I-2513 B & D 4B Meeting Minutes

I-2513B&D Concurrence Point 4B Meeting

Date: June 18, 2025
Location: CCA Structures Conference Room
Time: 1:00PM
Attendees: Hannah Headrick – NCDOT
John Jamison – NCDOT (Teams)
Todd Lapham – NCDOT
Carlos Sharpless – NCDOT (Teams)
Yates Allen – NCDOT (Teams)
Jennifer Parish – NCDOT (Teams)
Daniell Bagley – NCDOT (Teams)
Scott Jones – USACE (Teams)
Lori Beckwith – USACE (Teams)
Holland Youngman – FWS (Teams)
David Moyar – JV (Teams)
Byron Holden – RK&K
Jeremy Keene – RK&K
Pete Stafford – RK&K (Teams)
Chris Rivenbark – RK&K
Vidya Mohandas – WSP
Kase Schalois – WSP
Chris Lewis – TGS (Teams)

The Hydraulic Review was held in order to reach compliance on Merger Concurrence Point 4B, further known in the minutes as 4B, for I-2513B&D, I-26 / I-240 in Buncombe County. The following items were discussed and conclusions reached:

SITE 2

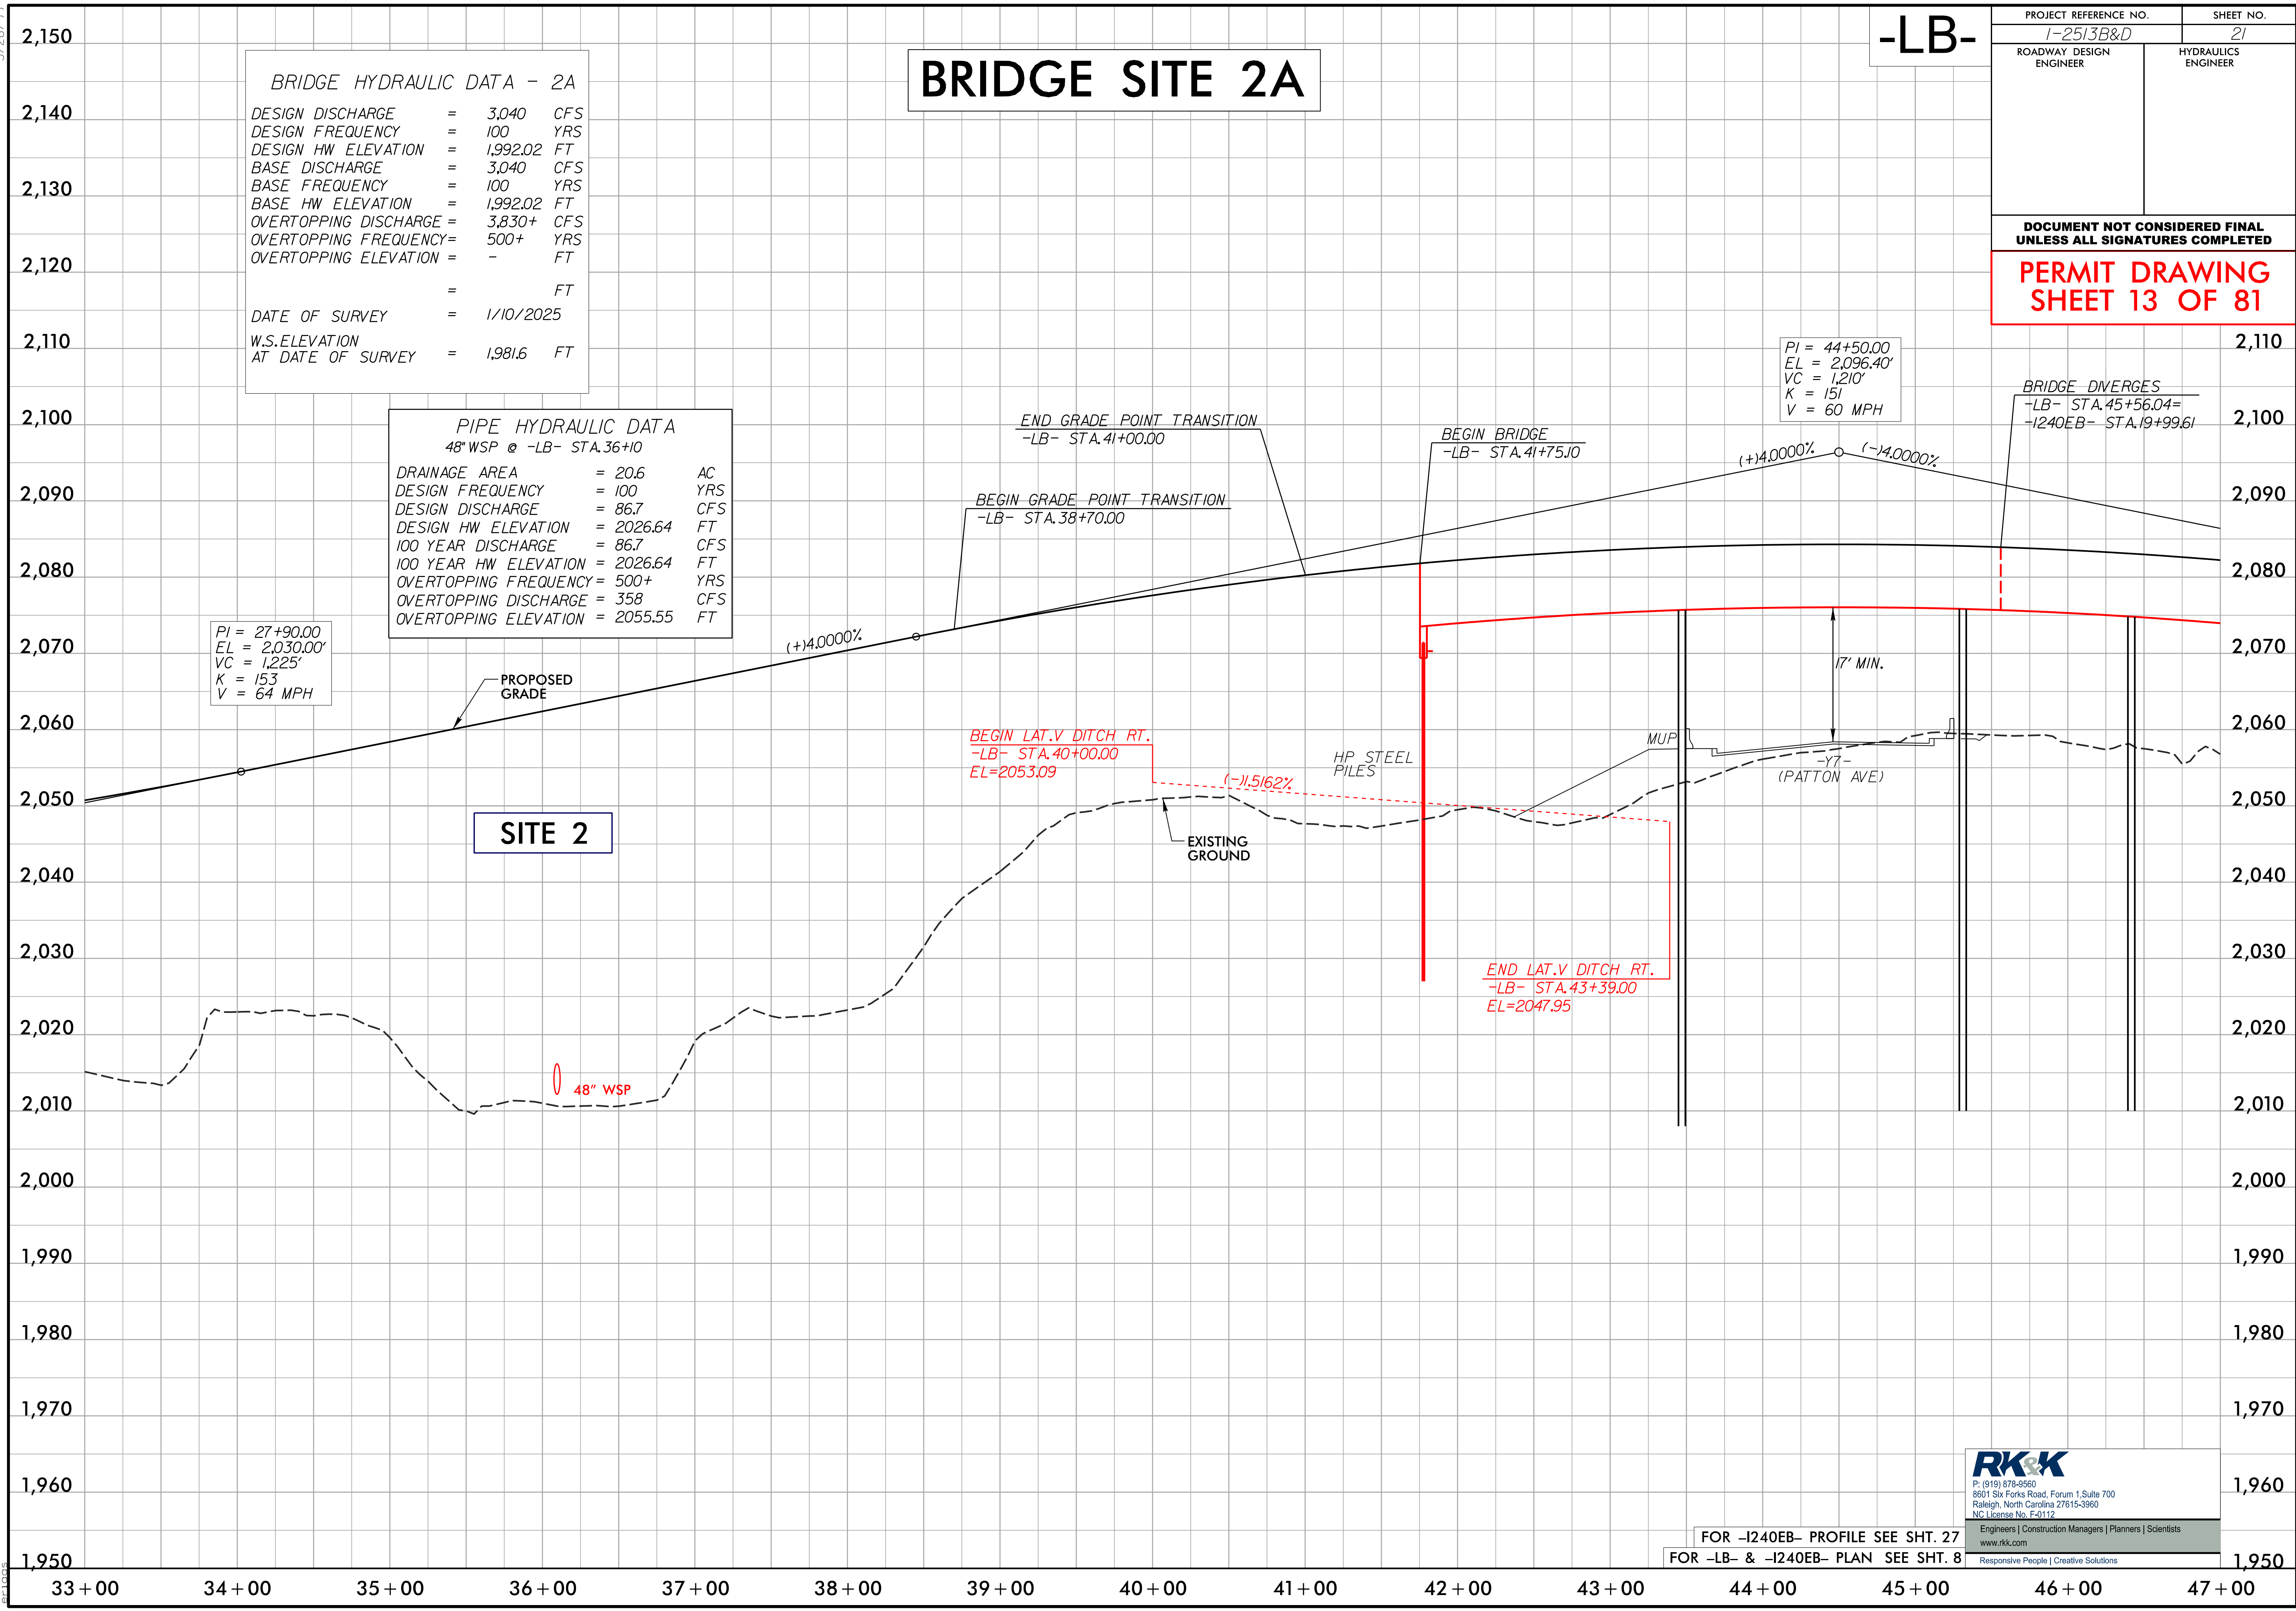
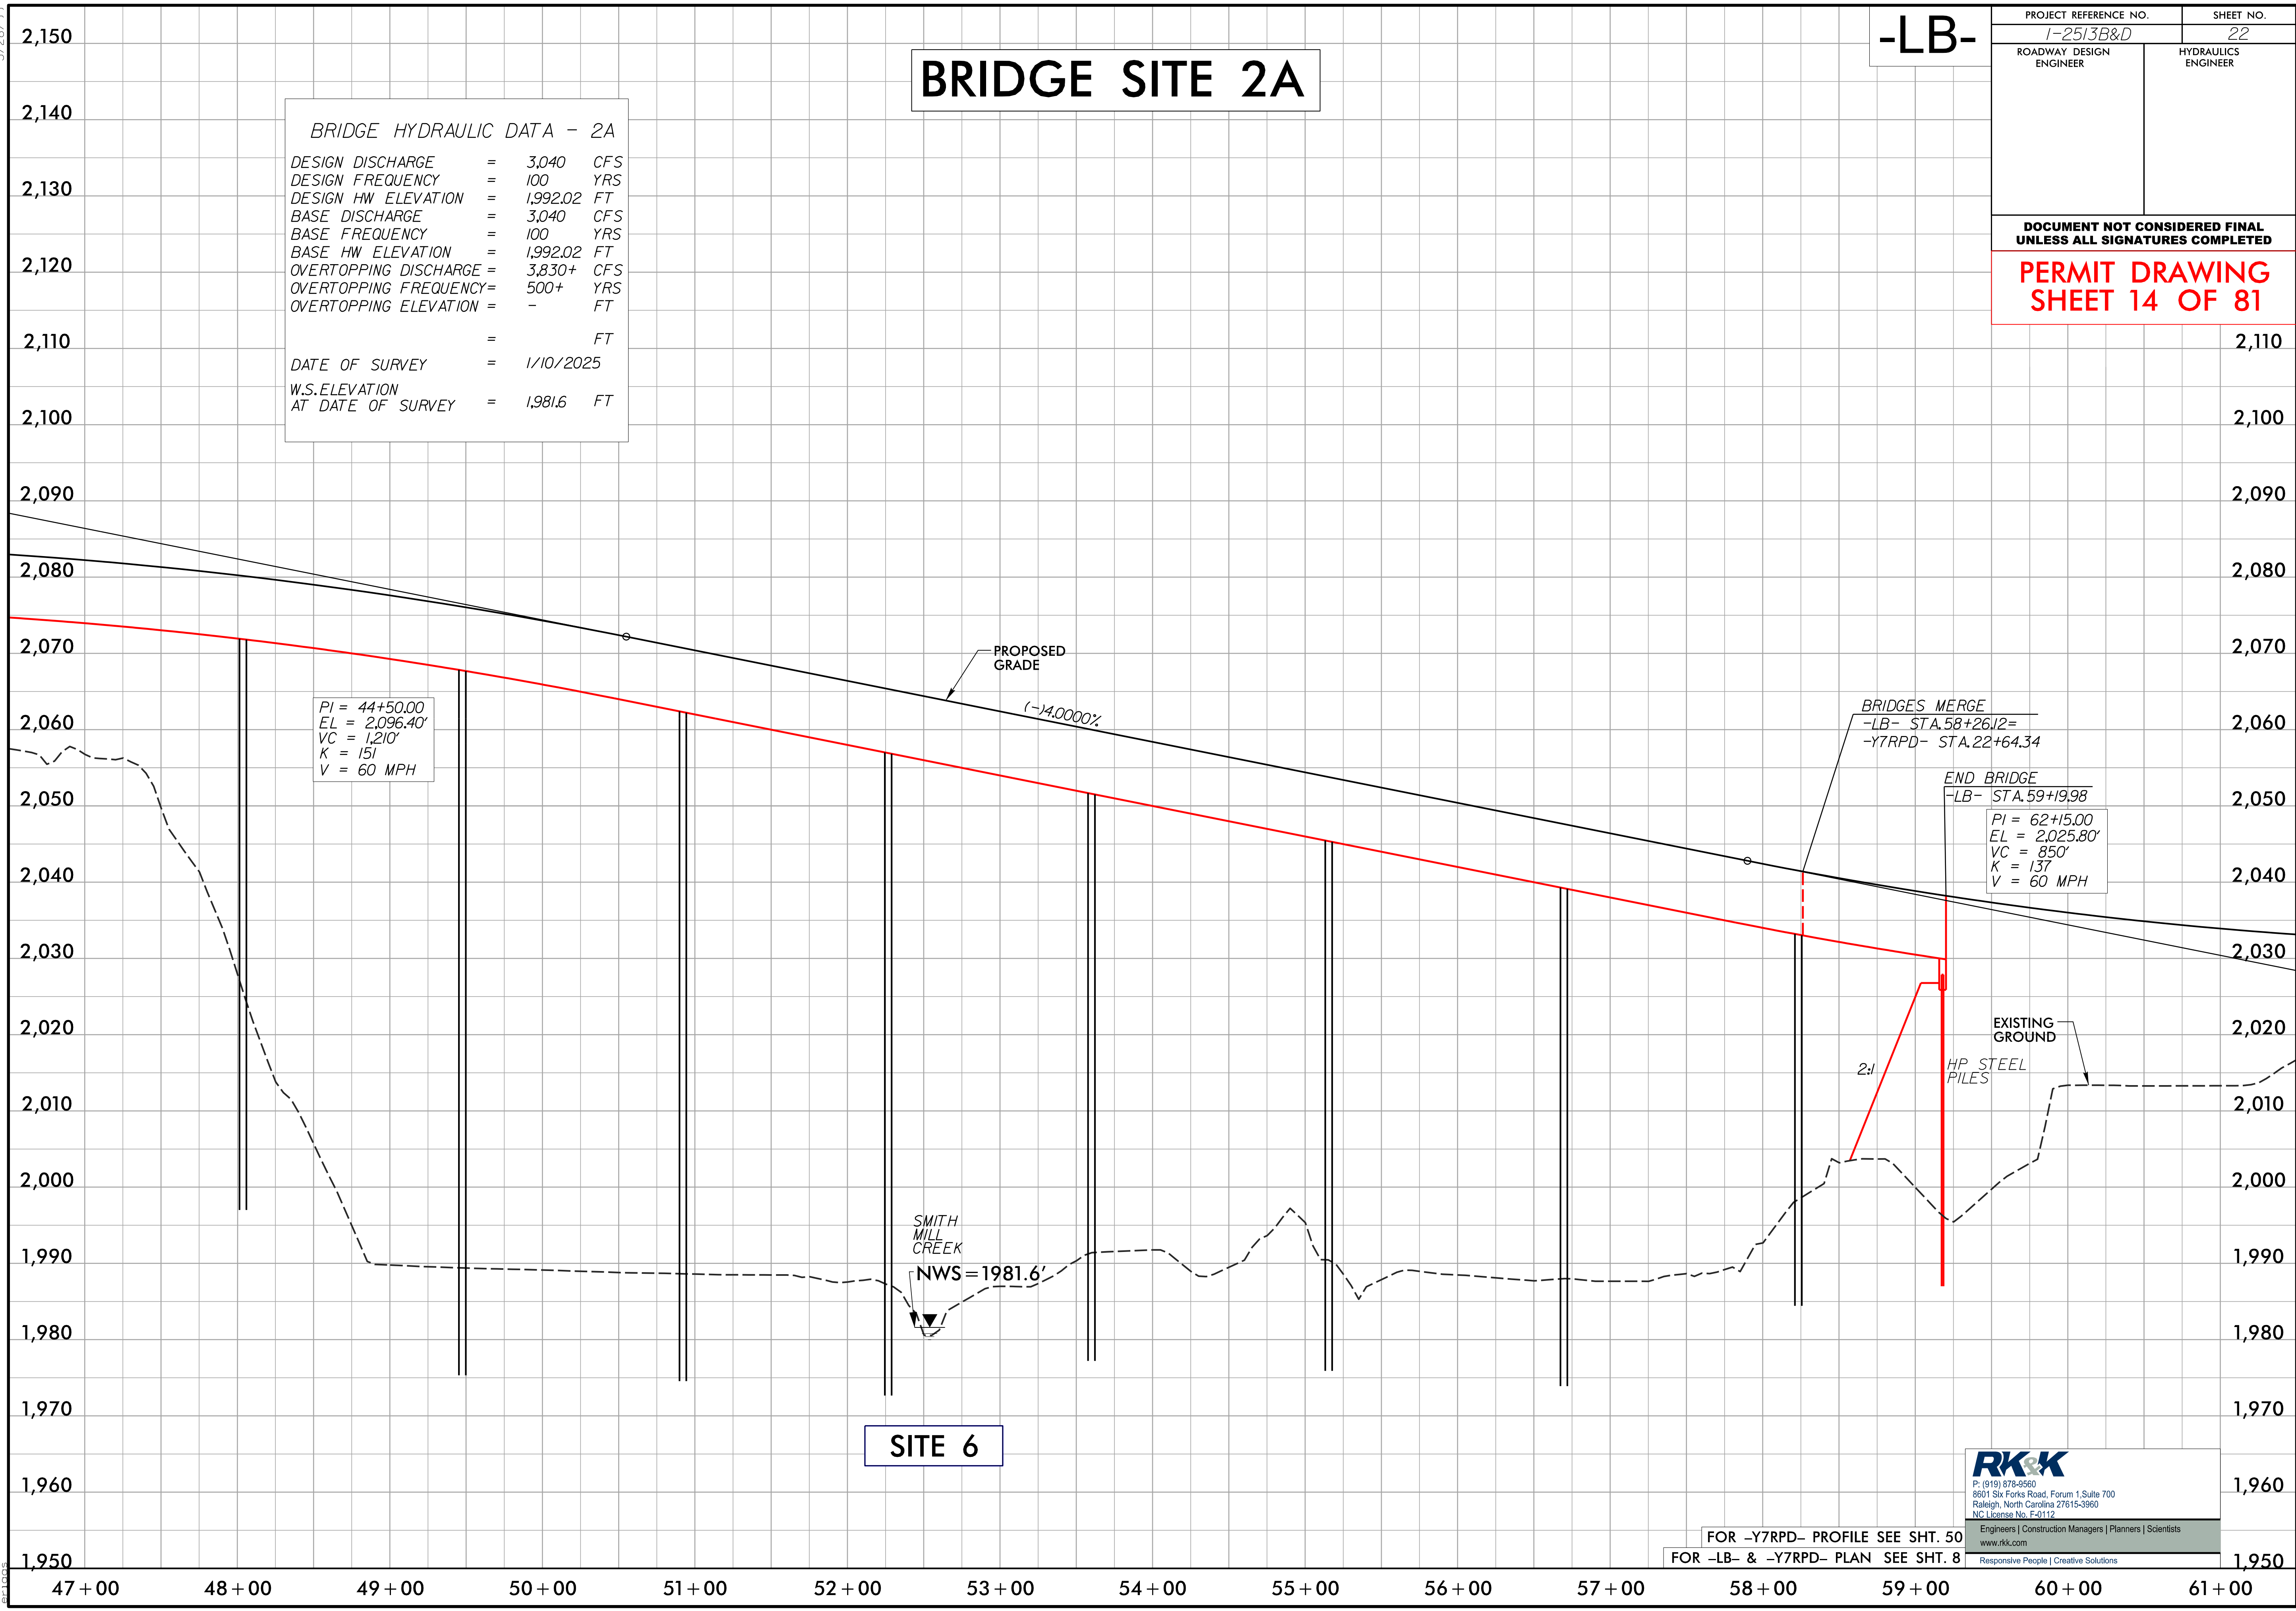
- Stream SU is Permit Site 2 in the preliminary permit.
 - SU is currently carried by an existing 30" RCP. The proposed design is now carrying SU in a 54" WS pipe that has been buried 1' due to it being jurisdictional.

- Mr. Cook asked if burying this pipe would be required since the pipe slope is greater than 3% and the pipe is 574' in length.
 - Dave McHenry and Lori Beckwith did not see an issue with it not being buried.

- Stream SU is not a total take since the stream continues beyond the study boundary.
- Wetland WC/WC2 were identified by RK&K since the preliminary permit.

- Since these new wetlands are adjacent to stream SU, Mr. Cook asked if they could be added to Permit Site 2 and everyone agreed to this.
 - Wetland WC is a total take since it is completely under the proposed fill slope.

- Mr. Cook asked if wetland WC2 should also be a total take or not since only about 50% is under the fill slope.
 - Ms. Beckwith said that it could be done either way. If NCDOT wanted to consider it a partial take, NCDOT would have to monitor the site. Mr. Cook replied that it would be most conservative to consider it a total take so that is how RK&K will proceed.
